## Review Letter

**DATE:** May 4, 2022

**FROM:** Jonathan Moore, PE, District Engineer

**RE:** The Cottages at Mesa Ridge – Construction Drawings and Final Plat dated April 5, 2022

SHEET **SAN** 21

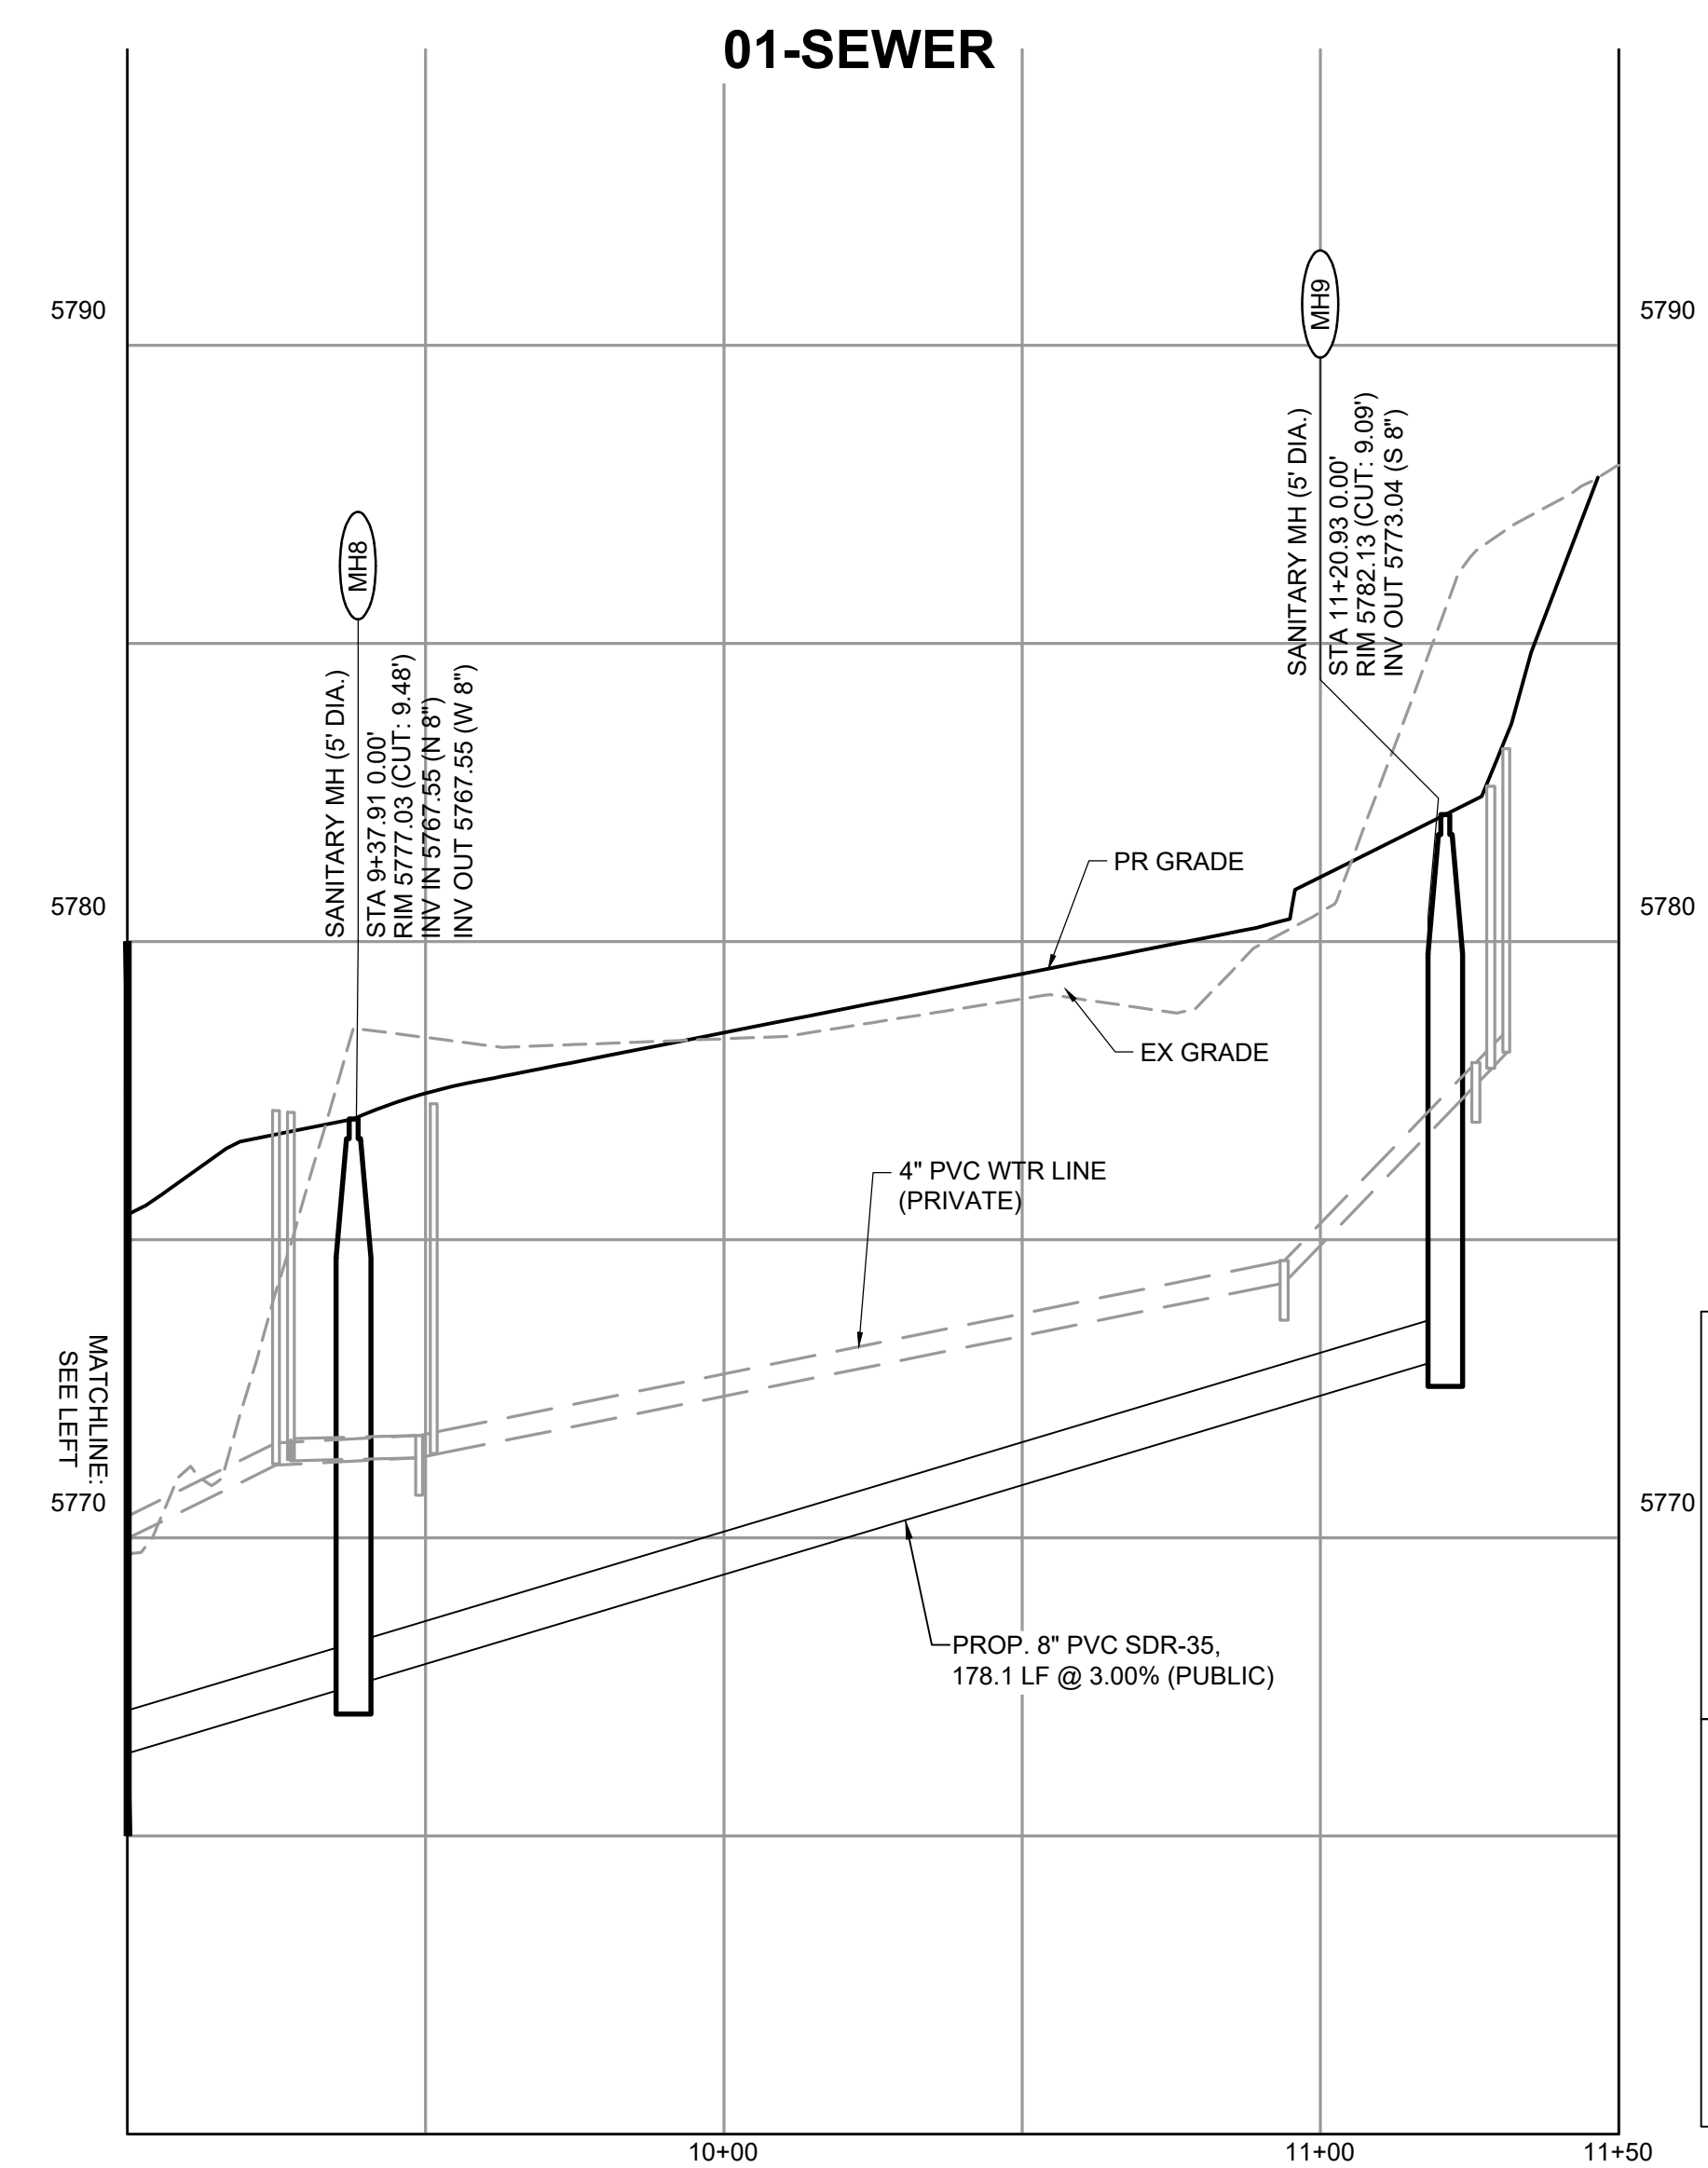
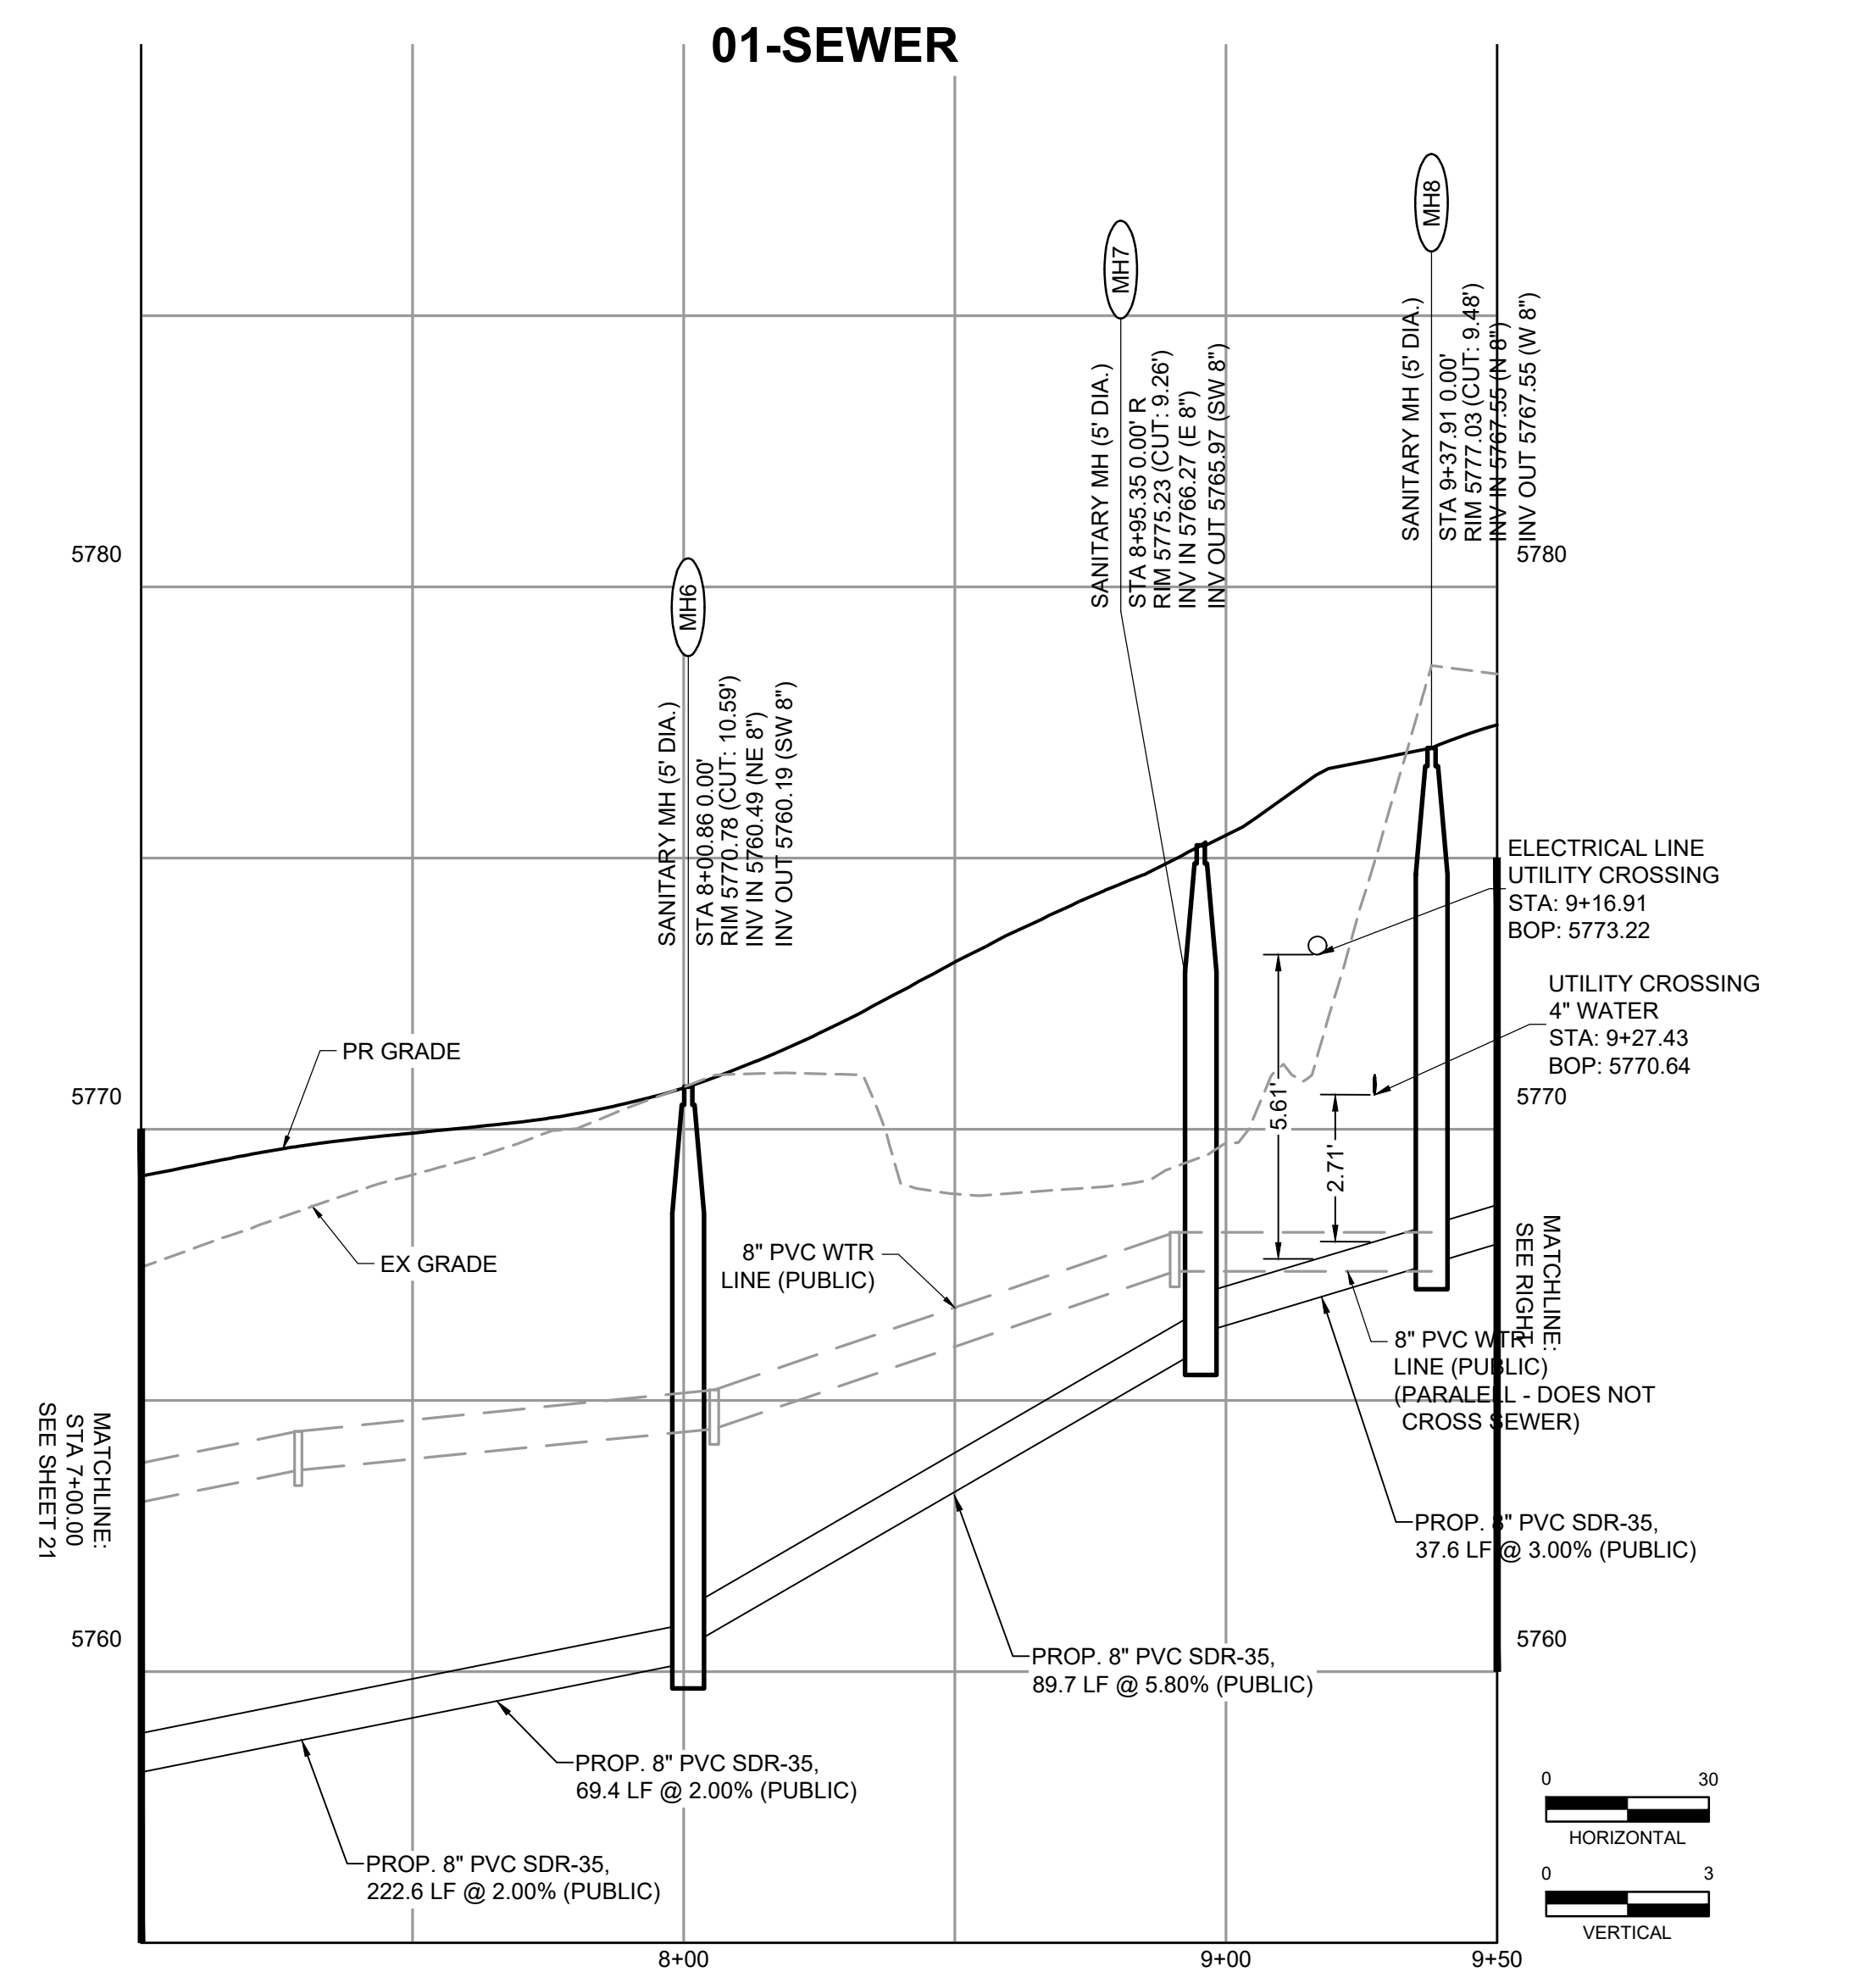
1. Add FSD signature block.
2. Create a plan and profile sheet with the plan on top and the profile on the bottom of the page, see FSD design regulations, Part B.
3. Label the sanitary sewer in the plan view as Prop. San. Swr. (Public) 8" PVC SDR-35.
4. Add Prop. 8" PVC SDR-35, xxxx LF at x.xx% (Public) to the pipe label in profile view.
5. Show the san. swr. radius in plan view, a minimum of 270' is allowed, add additional manholes as needed.
6. Show all utility crossings in profile, a minimum of 18" of vertical separation is required. Label all vertical separations in profile view.
7. Profile vertical lines should be spaced per the vertical scale. FSD prefers a horizontal scale of 30 and a vertical scale of 5.
8. All san. swr. manholes must be a minimum of 5' in diameter.
